Application for a non-material amendment following a grant of planning permission.
 Town and Country Planning Act 1990

Single storey rear extension.

24/00067/HOUSE

Amendment of approved plans for a gable roof over extension instead of hipped roof.

SITE:	The Smokery, Winhurst Lane Ide Hill, TN14 6LD		
TITLE:	Proposed East & West Elevations		
SCALE AT A3:	DATE:	DRAWN:	CHECKED:
1:100	03/01/24	BQ	BQ
PROJECT NO:	DRAWING NO:	REVISION:	
D32	A3/008	A

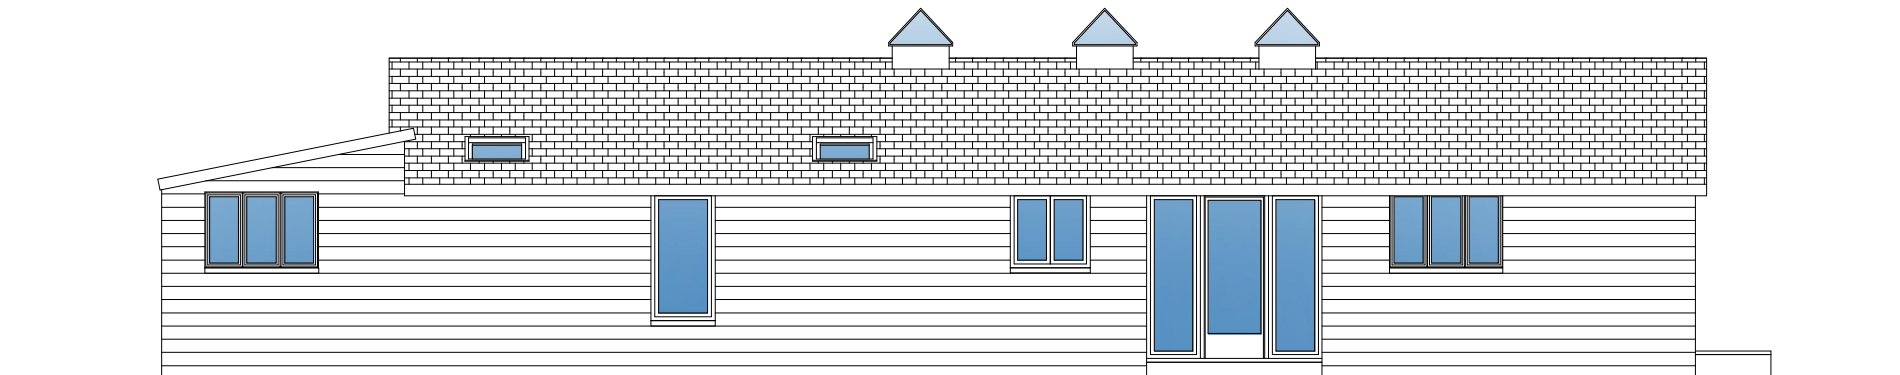
To improve the design of the extension and provide more natural light through a triangular window to gable wall. This will ensure better living conditions for occupiers.

A3/006 rev A, A3/007 rev A, A3/008 rev A, A3/009 rev A
